From: Planning and Engineering Referral Request <PlanReferralRequest@douglasco.gov>
Sent: Thursday, July 23, 2026 2:55 PM
To: Miranda Benson
Subject: Mountain Village Preliminary Plan - File # SP265
Attachments: Referral Comments Report.pdf

Project: Ben Lomand Mountain Village Preliminary Plan

Project Name: Mountain Village Preliminary Plan

Project Number: RE2026-076

PRELIMINARY PLAT

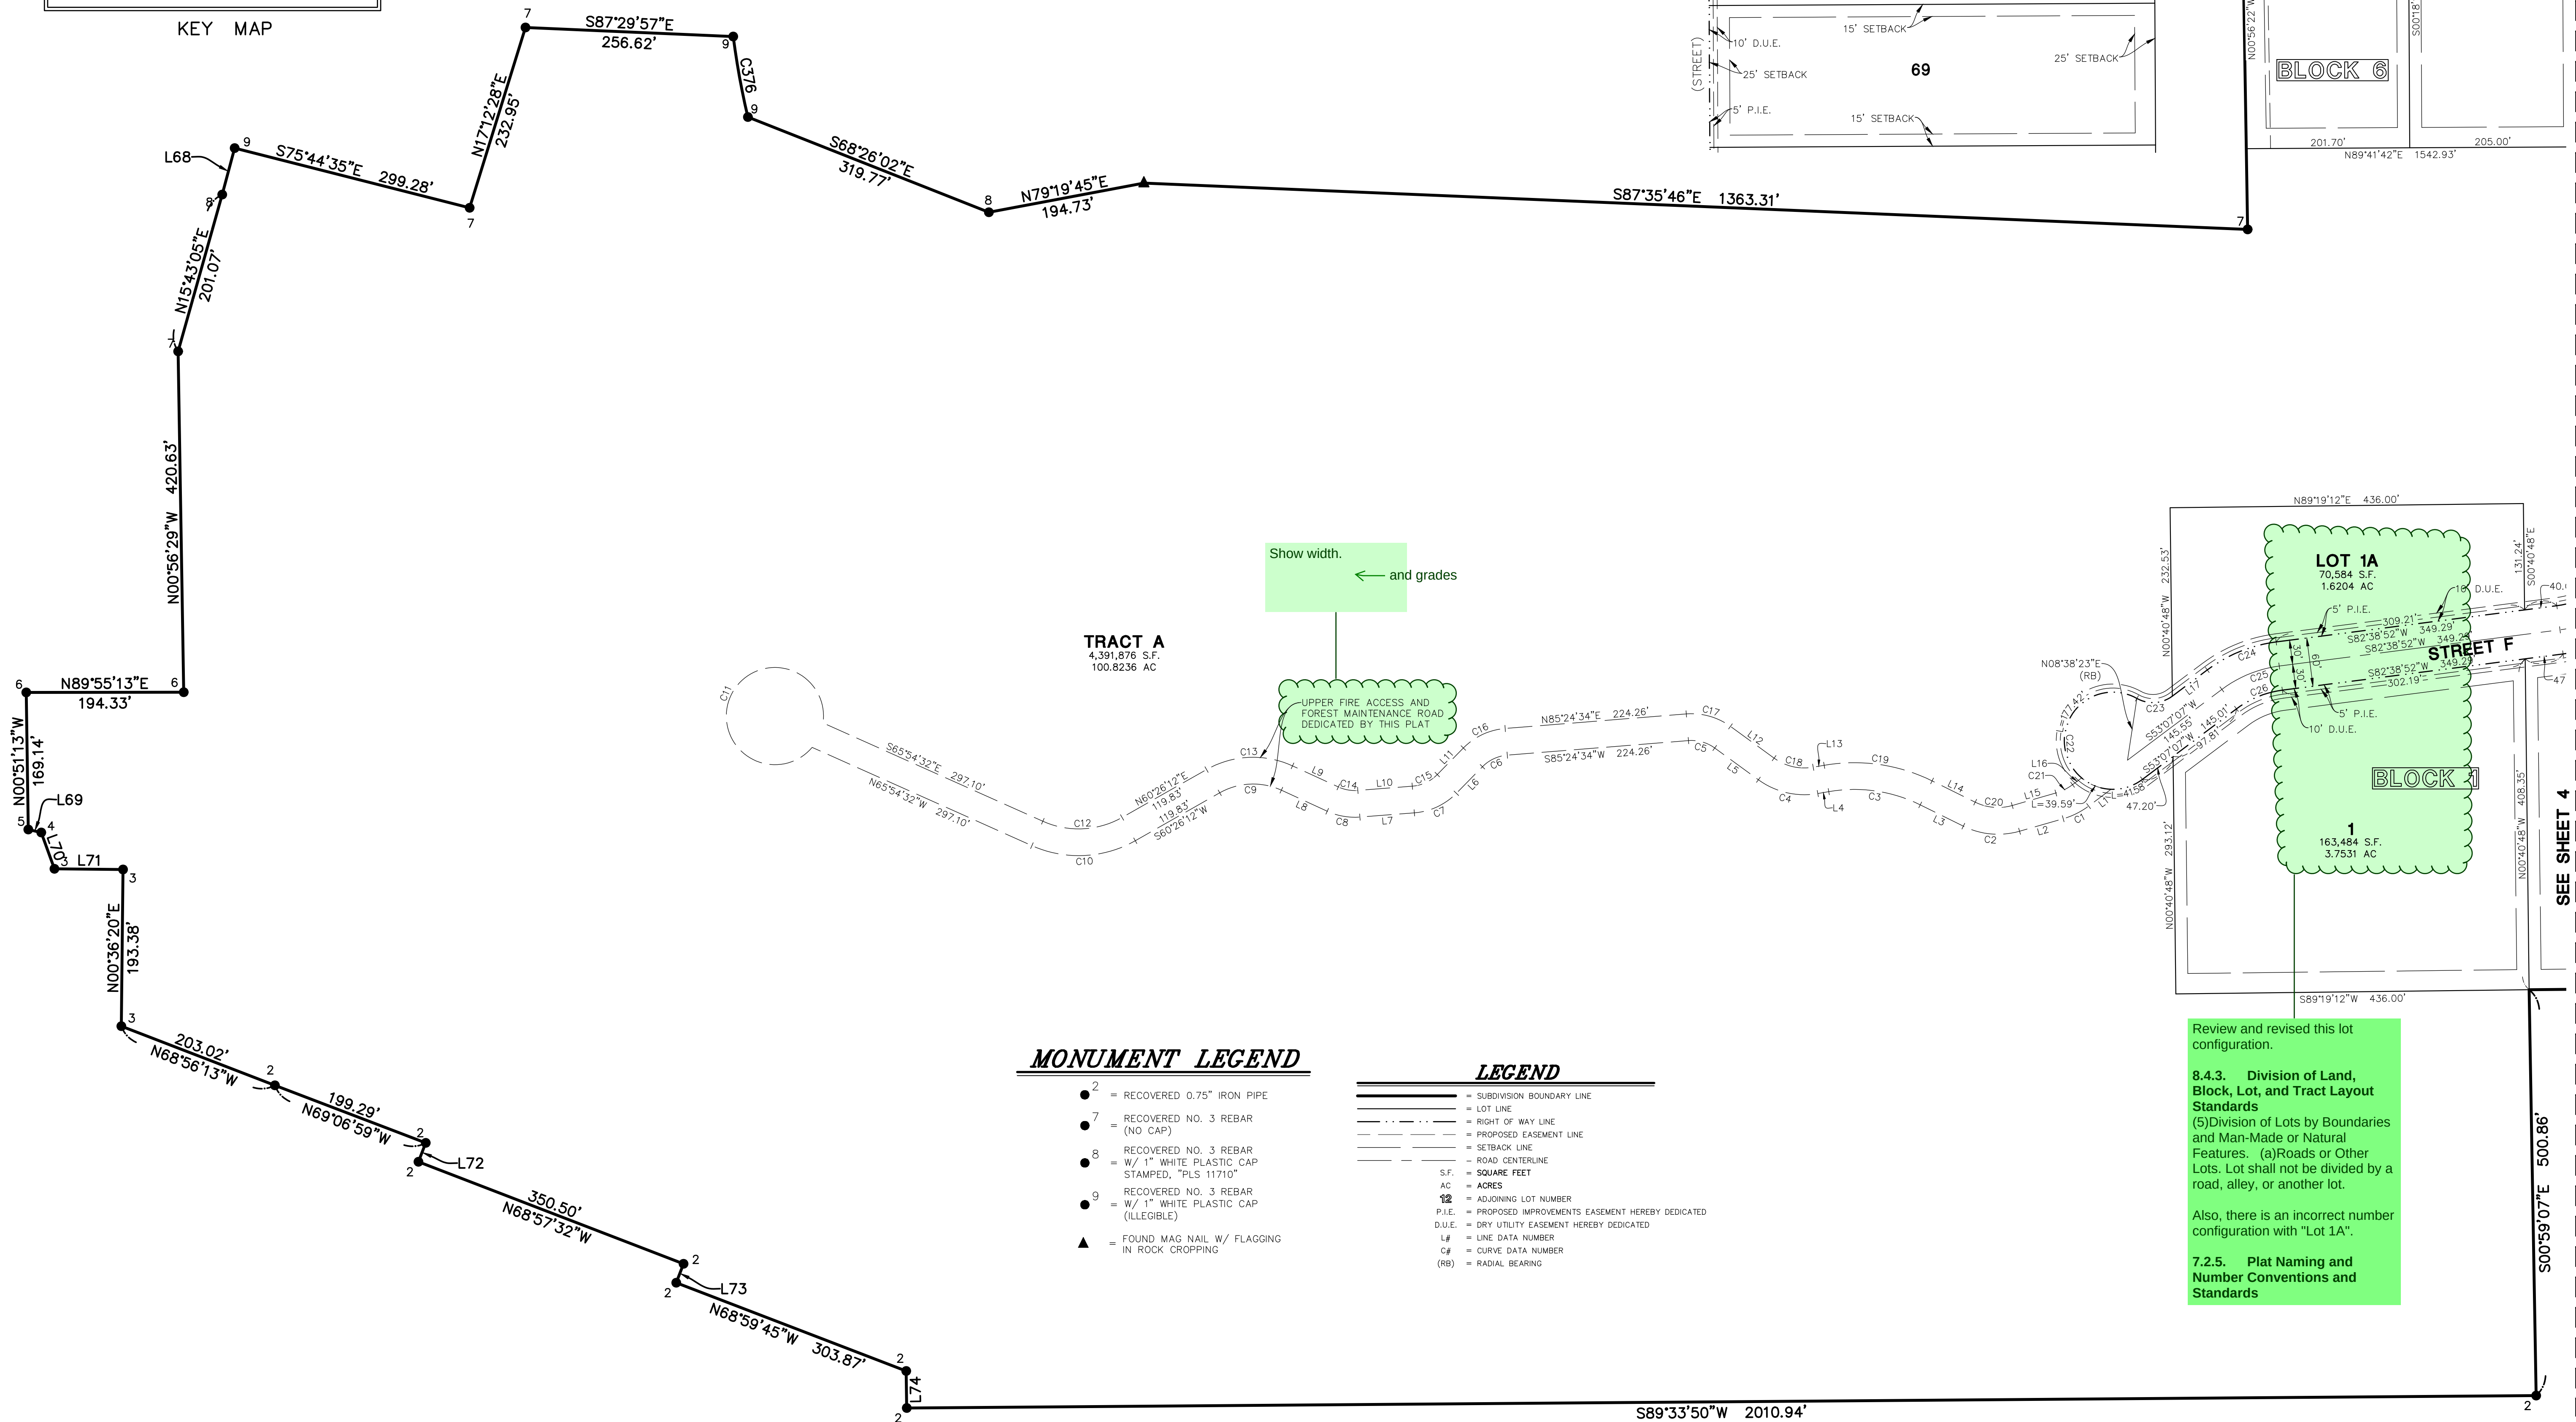
Is Lot 1A a separate buildable lot? There was no reference on the plan to its designation. If so, it should receive a number designation without the letter suffix to reflect there are 73 lots.

BEN LOMAND MOUNTAIN VILLAGE
EL PASO COUNTY, CO
DETAILED GRADING PLAN 2

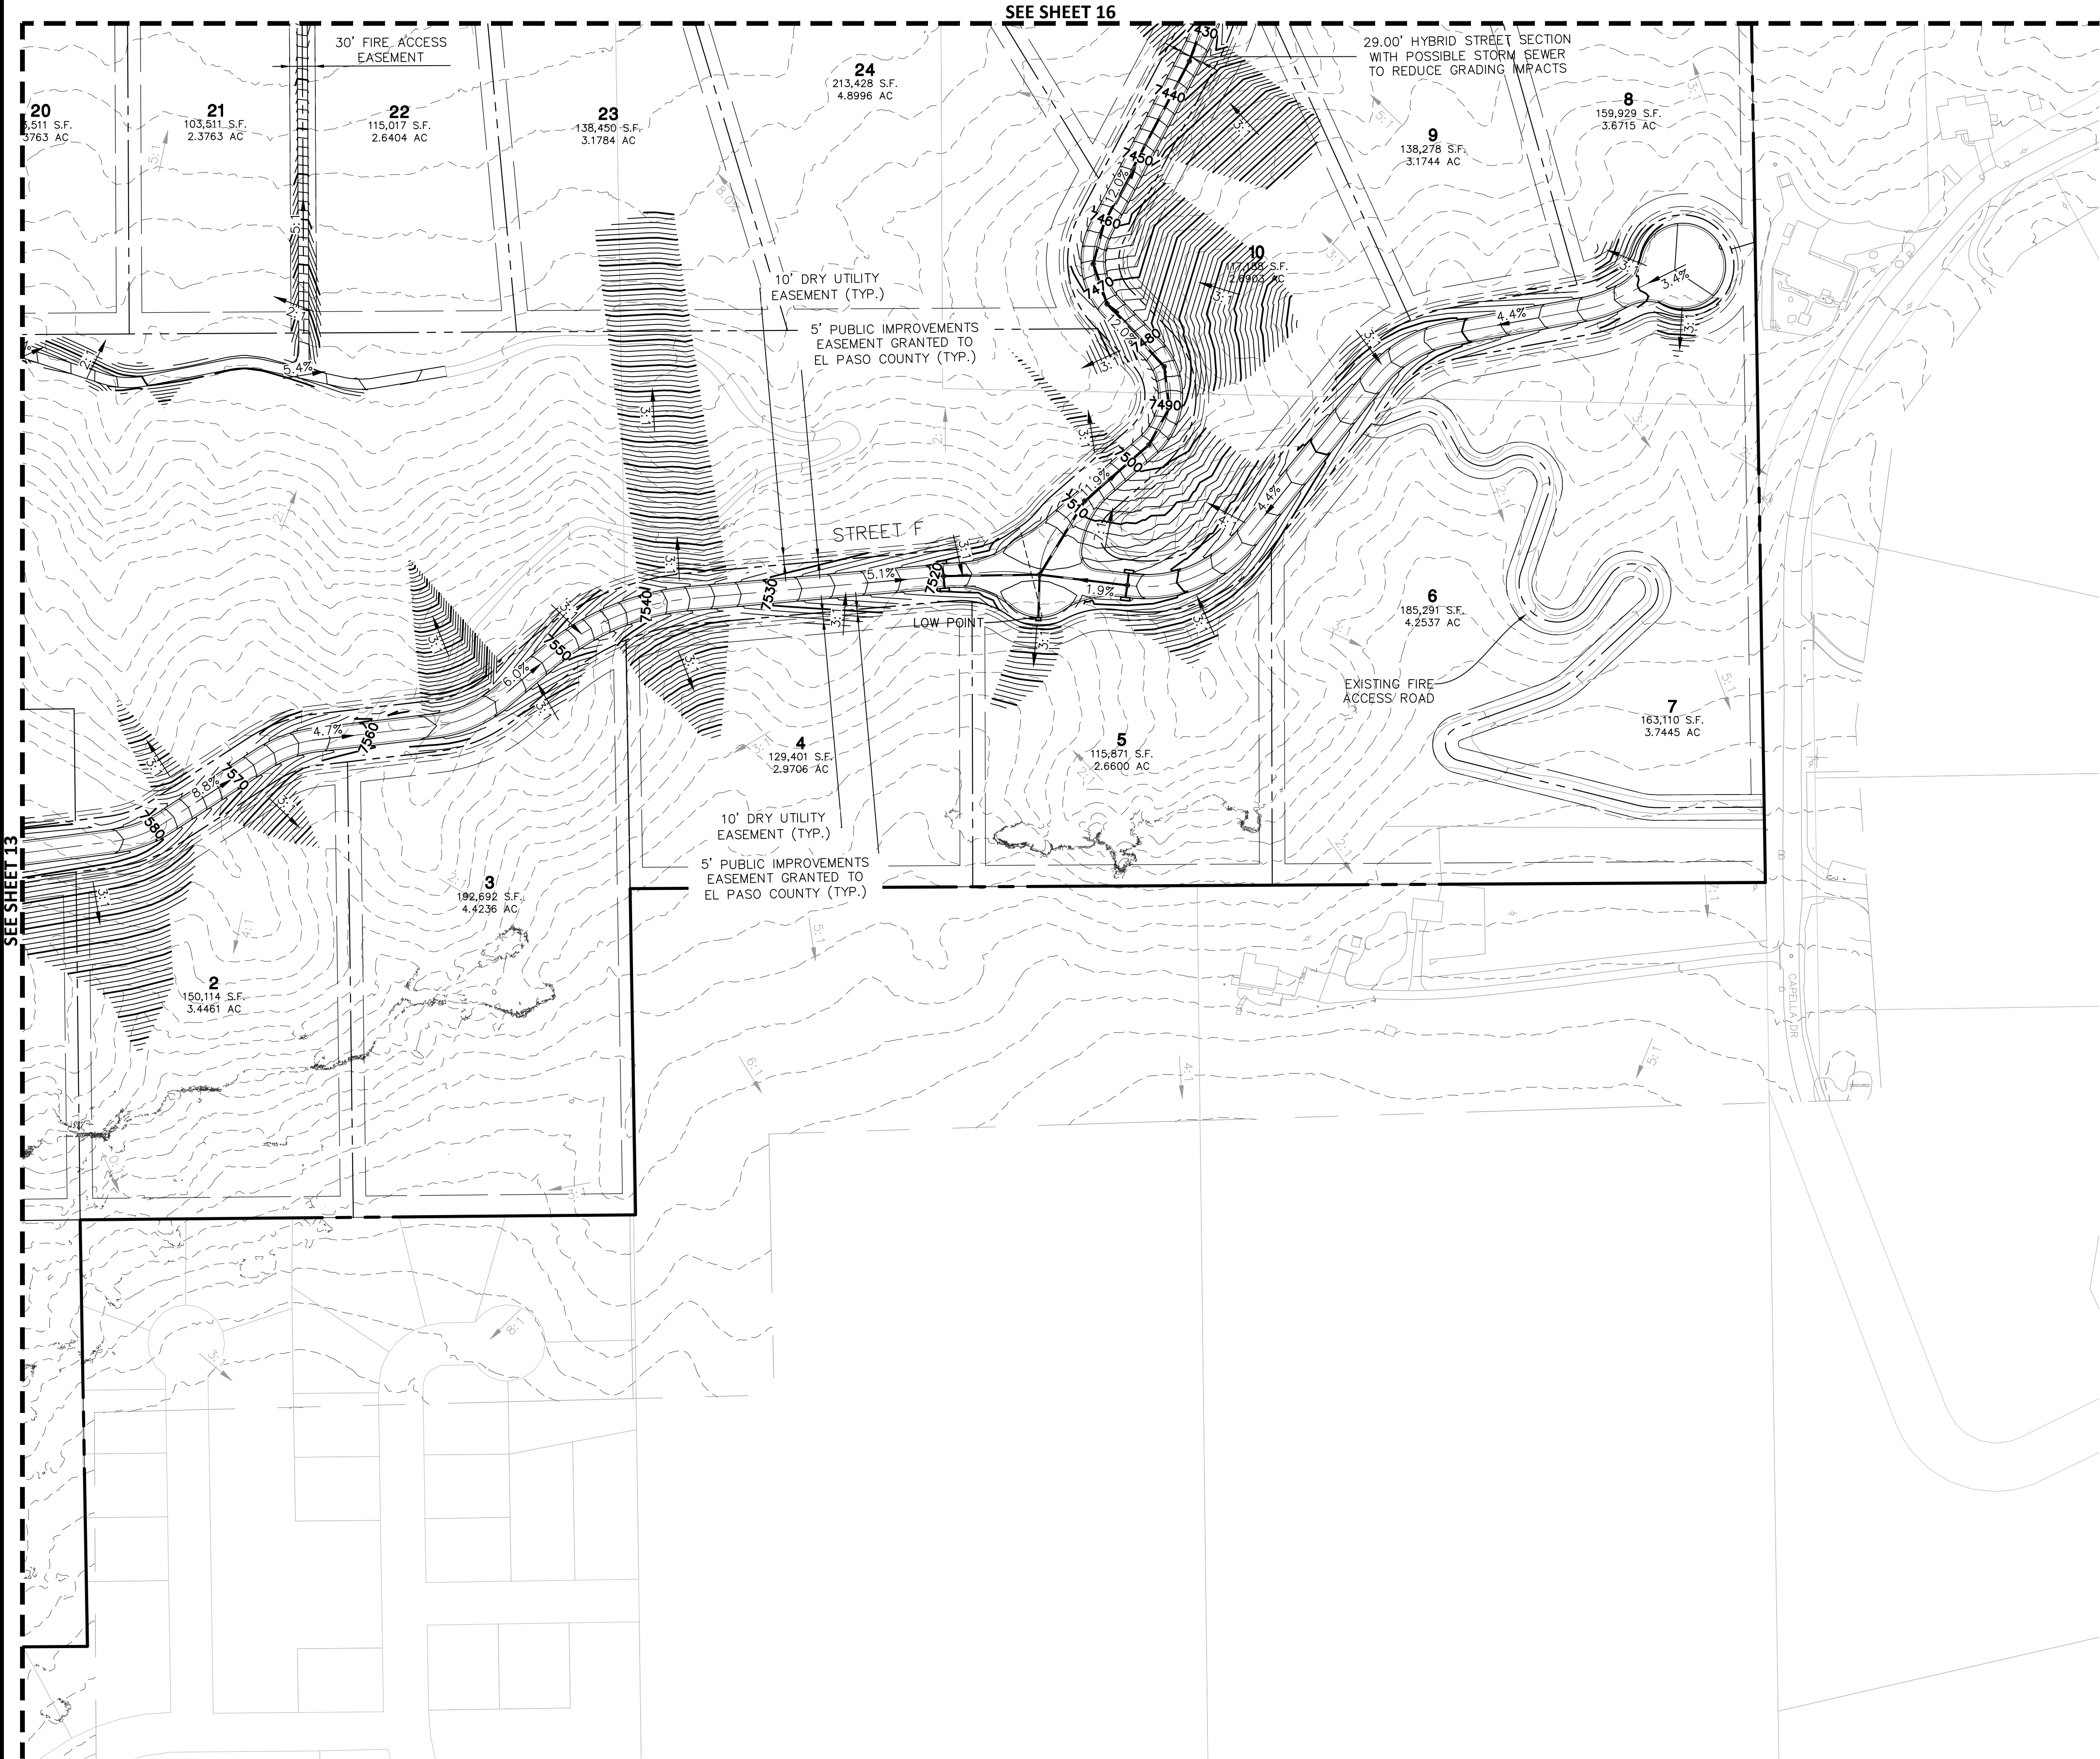
Many of southern lots are steep slopes of 25 to 50%, is it feasible for these lots to be accessed and built upon? Based on the proposed grading and topography is there buildable area on Lots 4 and 10?
